From: Richard Sherman
Sent: 29 November 2021 17:32
To: Planning Scanning
Subject: FW: BE/101/21/HH - 3 Homing Gardens, Bersted
Attachments: 3 Homing Gardens North Bersted. Revised Elevations Dwg PL.1B.pdf; 3 Homing Gardens North Bersted. Revised Elevations Dwg PL.2B.pdf; 3 Homing Gardens North Bersted. Revised Floor and Roof Plans Dwg PL.3A.pdf

We are looking over your application for 'Replace metal framed/wood panel workshop in rear with brick-built workshop (This application may affect the character and appearance of the North Bersted Conservation Area) at the above address.

extending homes Tel:- 01243 555208 enquiries@extendinghomes.co.uk	
TITLE:- Outbuilding @ 3 Homing Gardens North Bersted West Sussex PO22 9AJ	
DATE:-	2nd September 2021
SCALE:-	Elevations Scale 1-100 on A2 Paper
DRAWN:-	P.Robinson
DWG. No. 2021078/PL/1

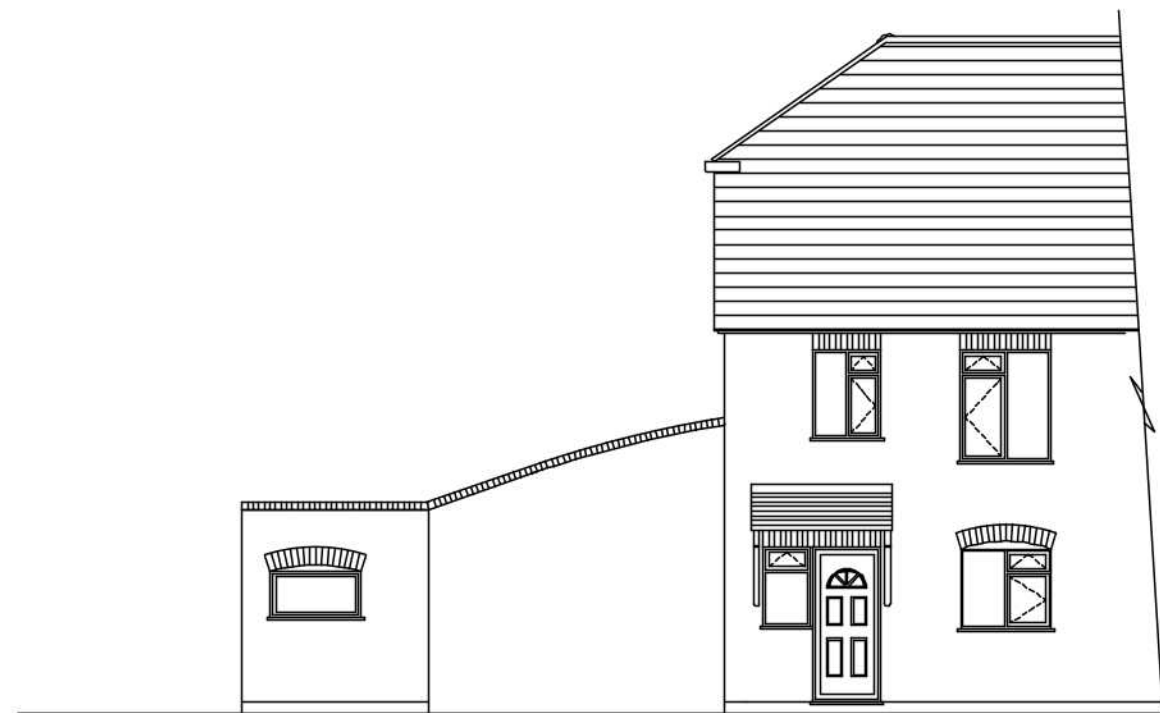
However on the Proposed Elevations plans you have submitted, they have been labelled incorrectly as 'Existing and Proposed NEE' and 'SWW' Please see snapshot below:

Therefore please can you amend these and resubmit these plans to me as they are supposed to be NNE and SSW?

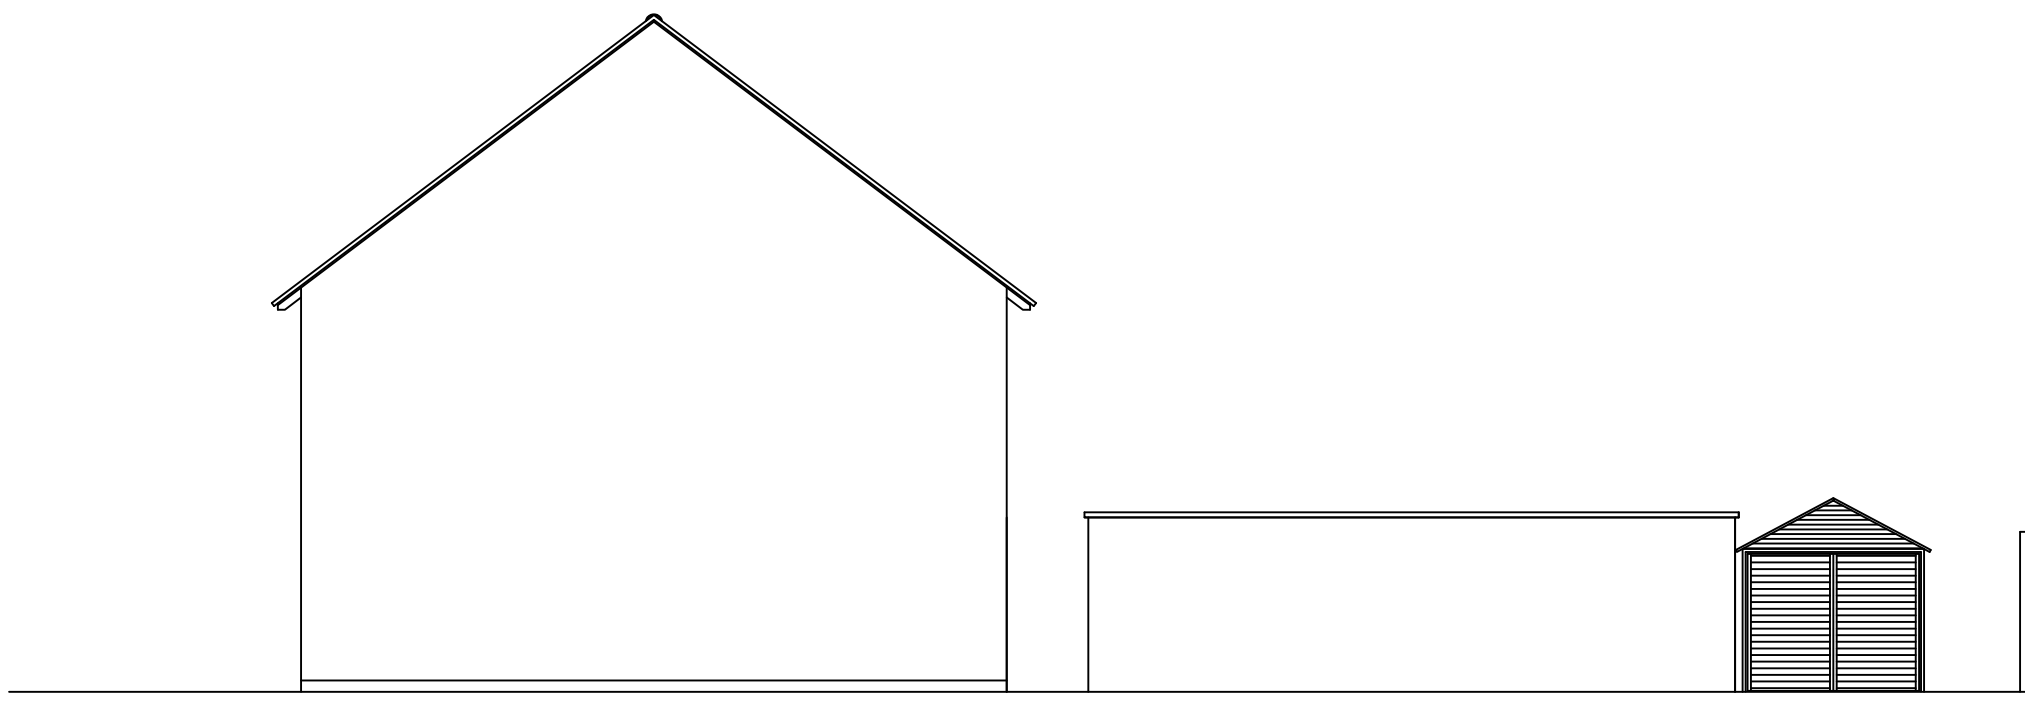
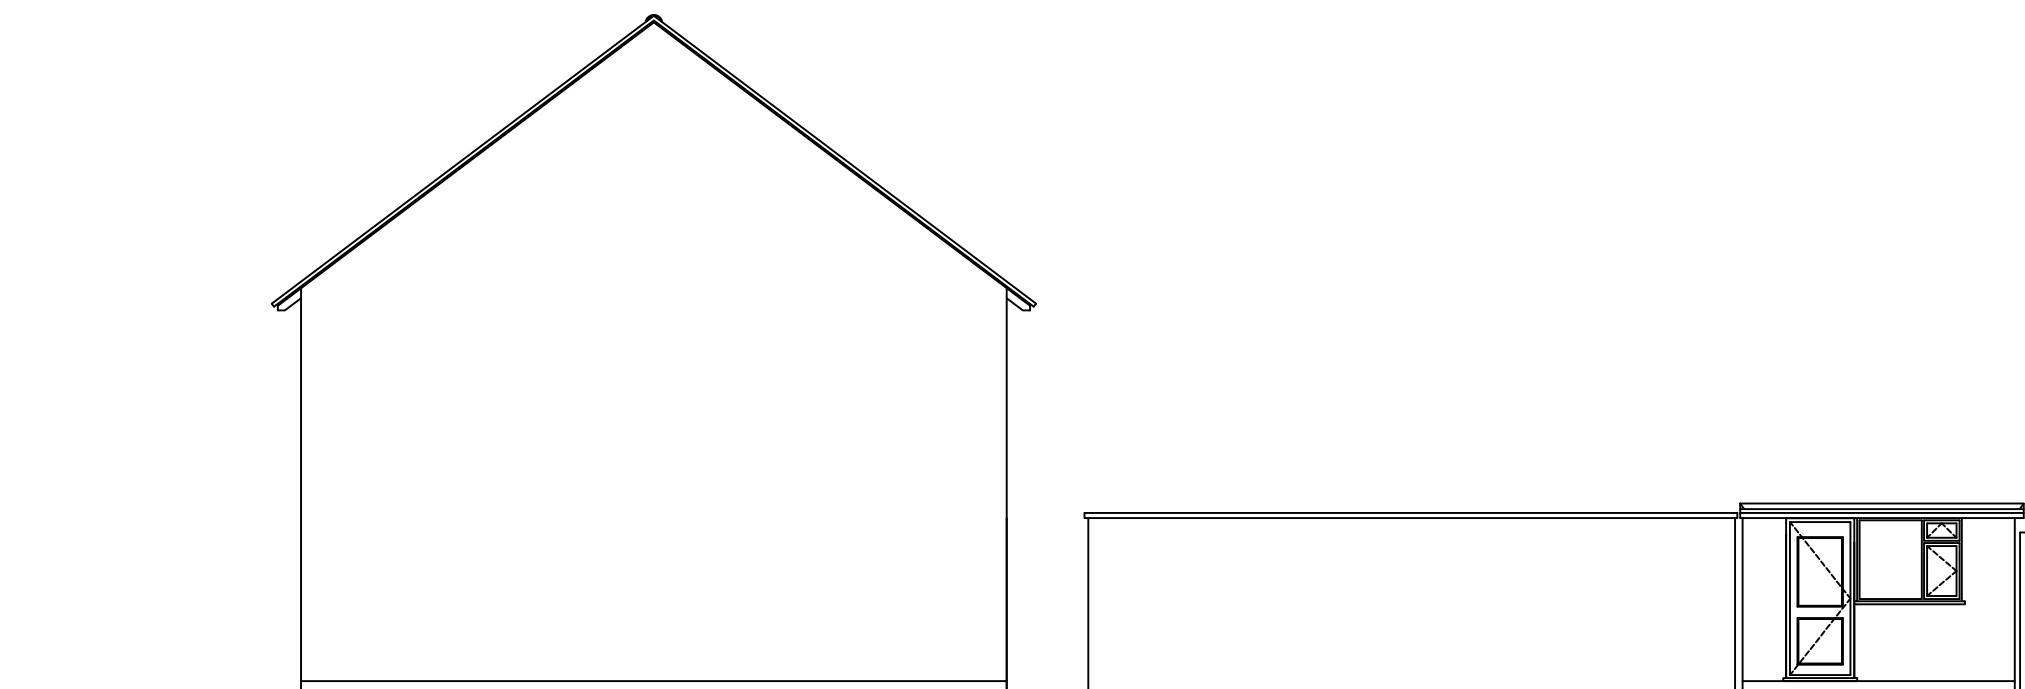
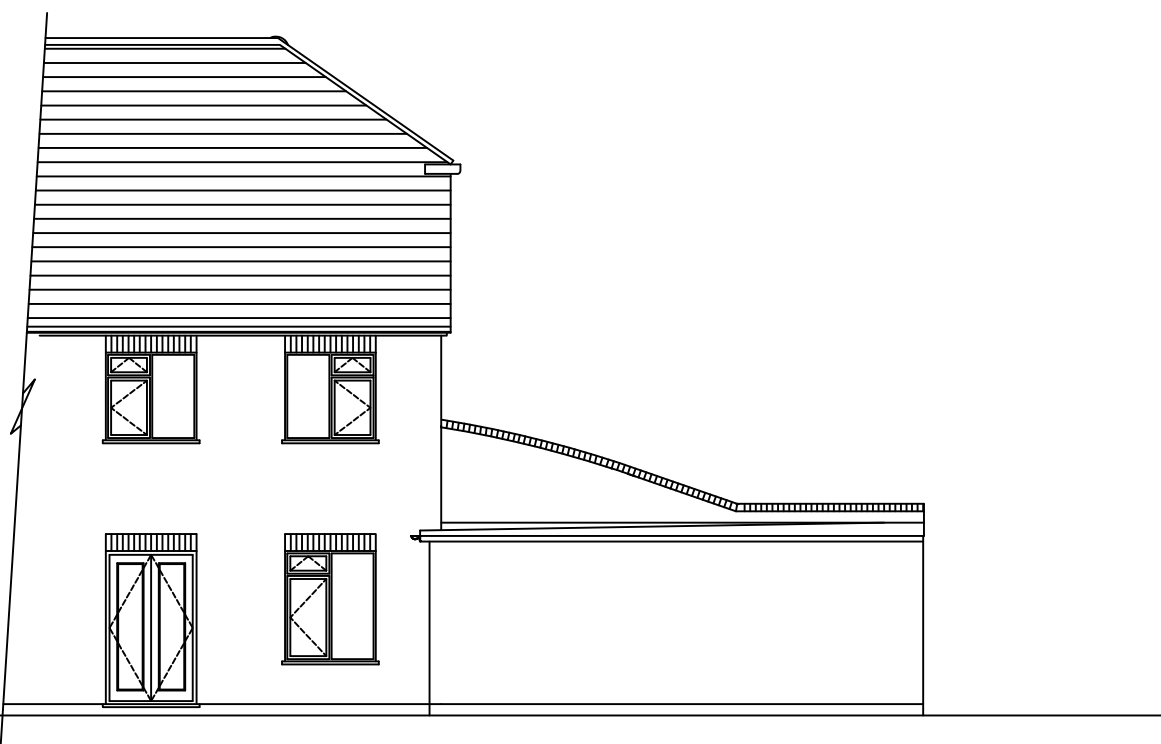
Attached are new PDF's. 1B, 2B and 3A. Responding to No. 7s comment about linking to his wall, I have revised to show totally separate workshop.
